Project Name: Wintergreen Apartments

**RE: WINTERGREEN APARTMENTS
10932 GOLF COURSE RD NW.
ESC PLAN RESPONSE TO COMMENTS – A12E008D**

Per the correspondence dated October 19, 2021, please find the following responses addressing the comments listed below:

SB-3Pond Volume Calculation	
Area at Mid Depth	2,815 Sq. Ft.
Depth of Pond	4 Ft.
Total Volume	11,258 Cubic Ft.

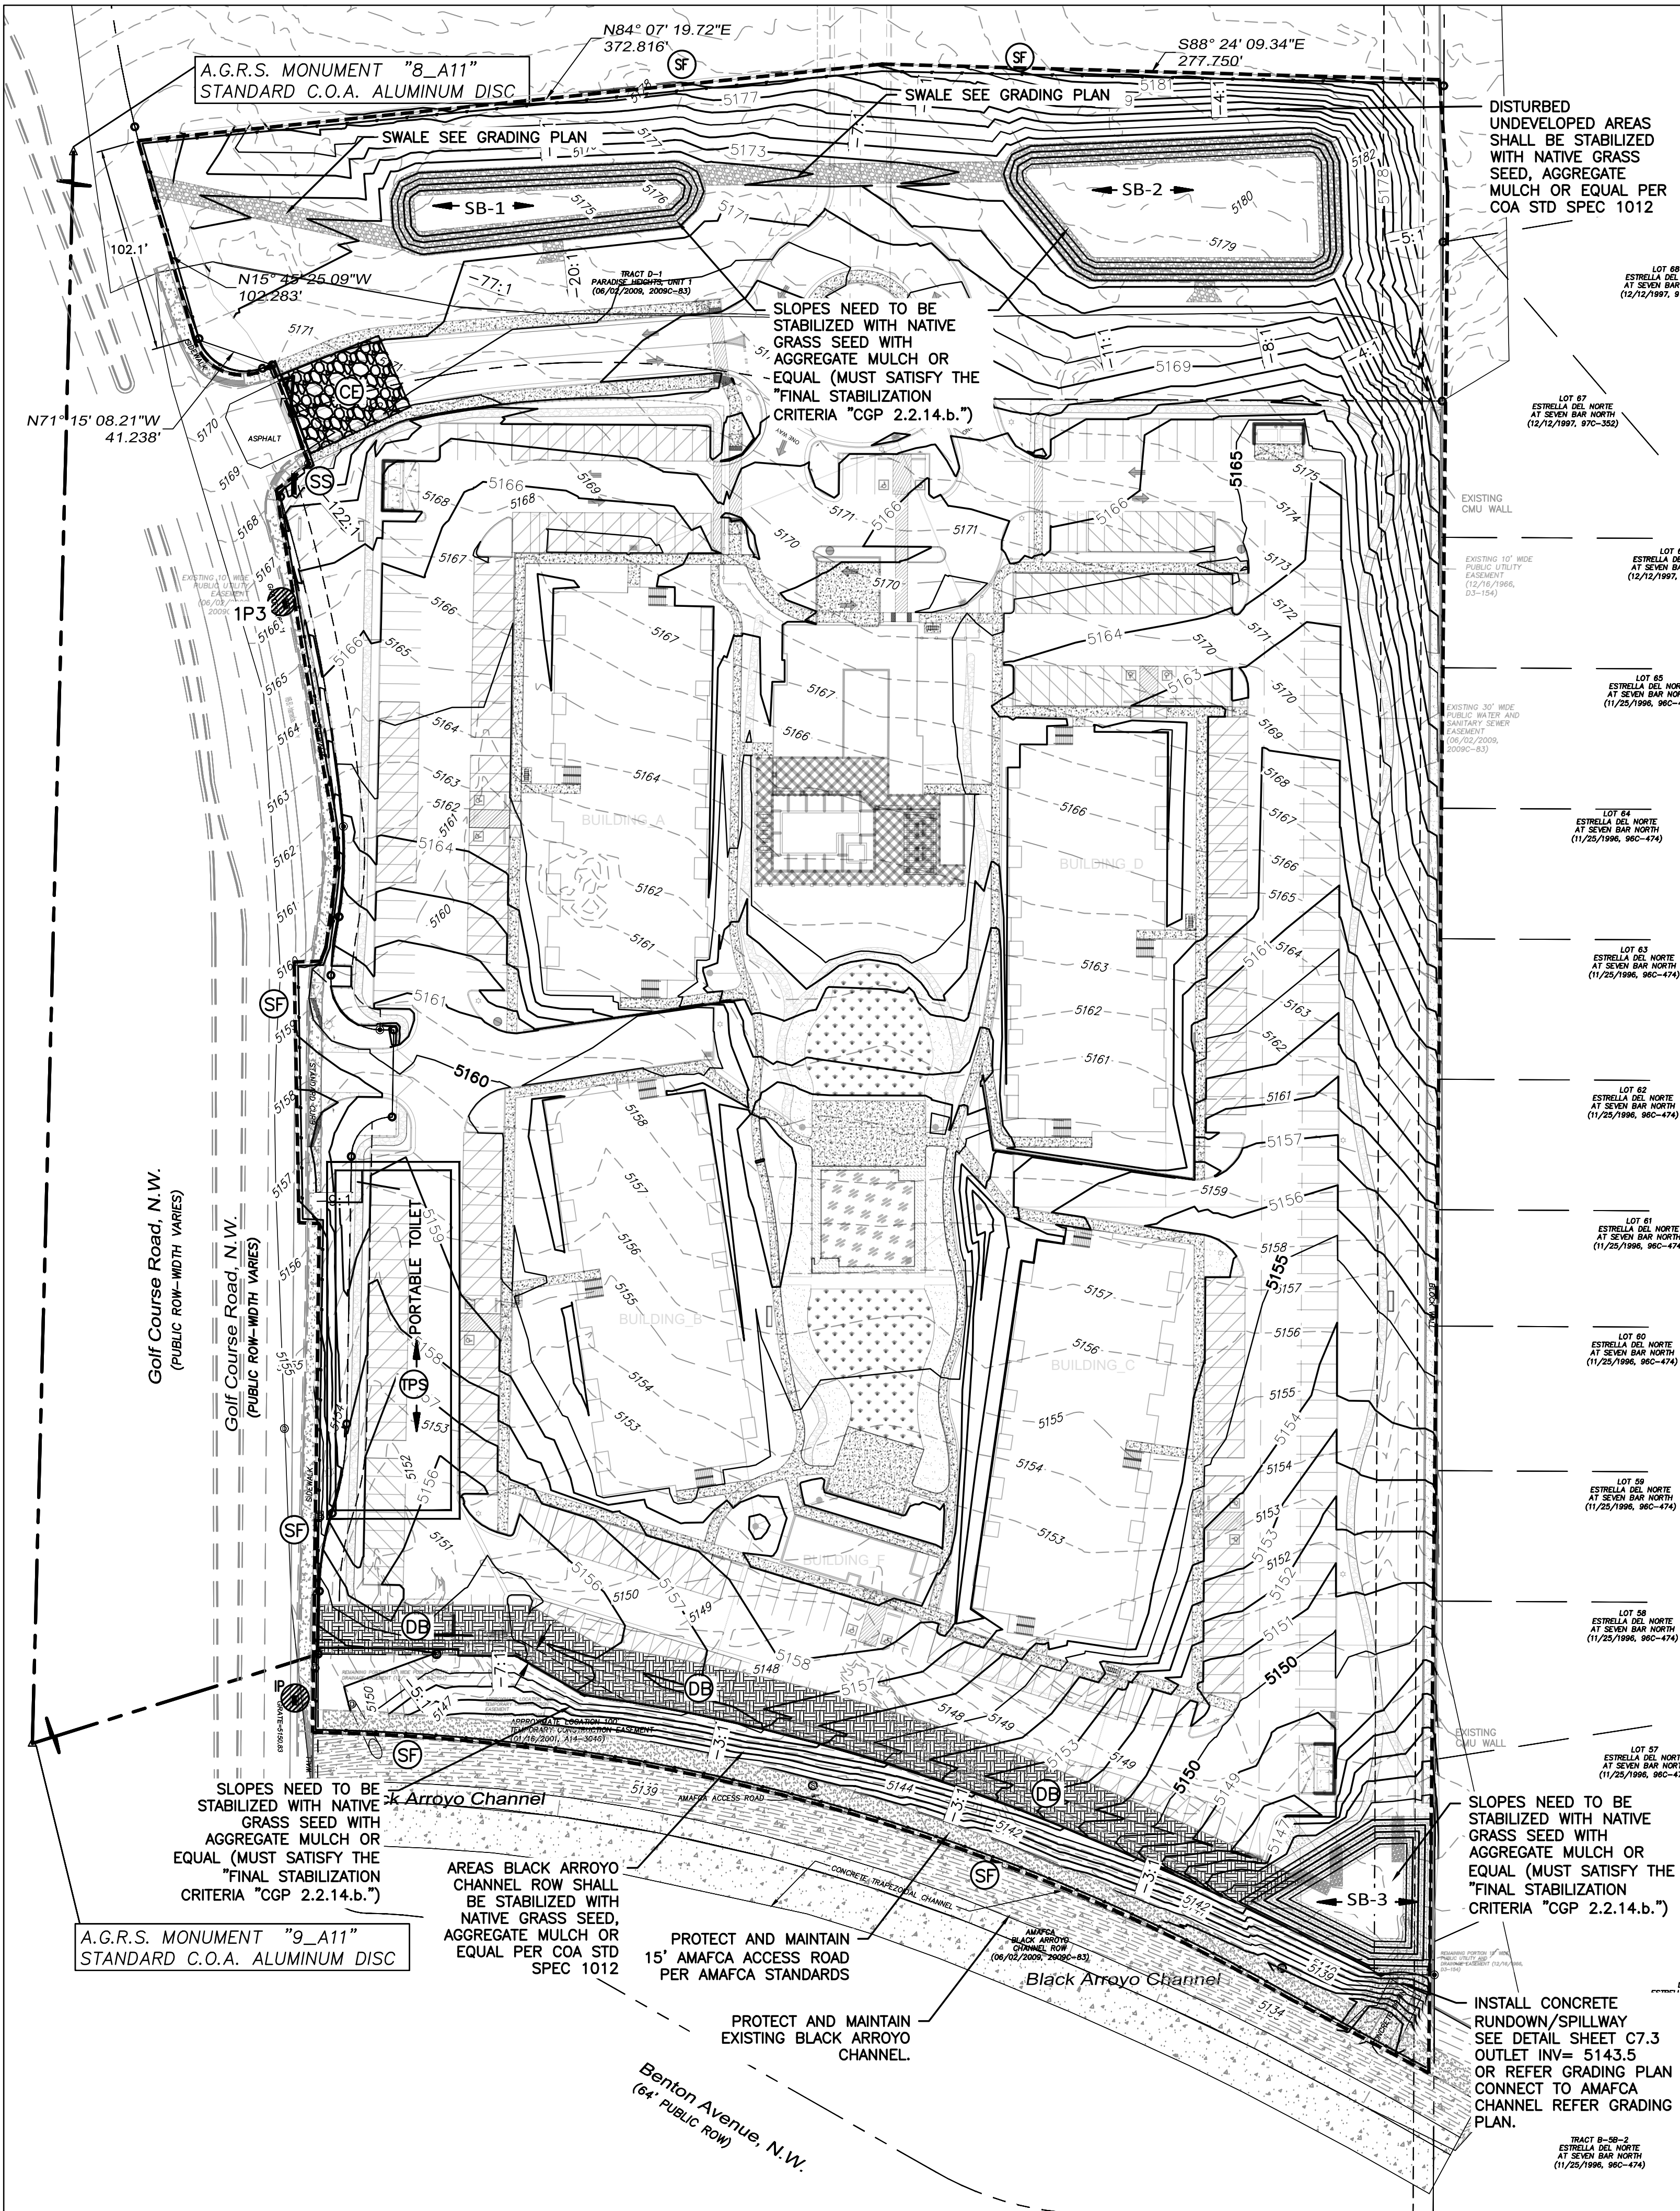
3. Stabilization measures are not identified on the Landscape Plan for the grading on the adjacent parcel to the north. Erosion Control note 7 on sheet C7.2 covers the deadlines, but General Erosion Note 'O' would be more specific and accurate if it says Temporary Cover and Final Stabilization (Part 2.2.14 (a) and (b) respectively) are to be per COA STD SPEC 1012 Native Seed with Hydromulch and Aggregate Mulch respectively.

RESPONSE: Acknowledged, Note 'O' was updated and additional stabilization language was added to ESC plan for the north lot and AMAFCA ROW.
4. More detail is needed for the outlet structure at SB#3.
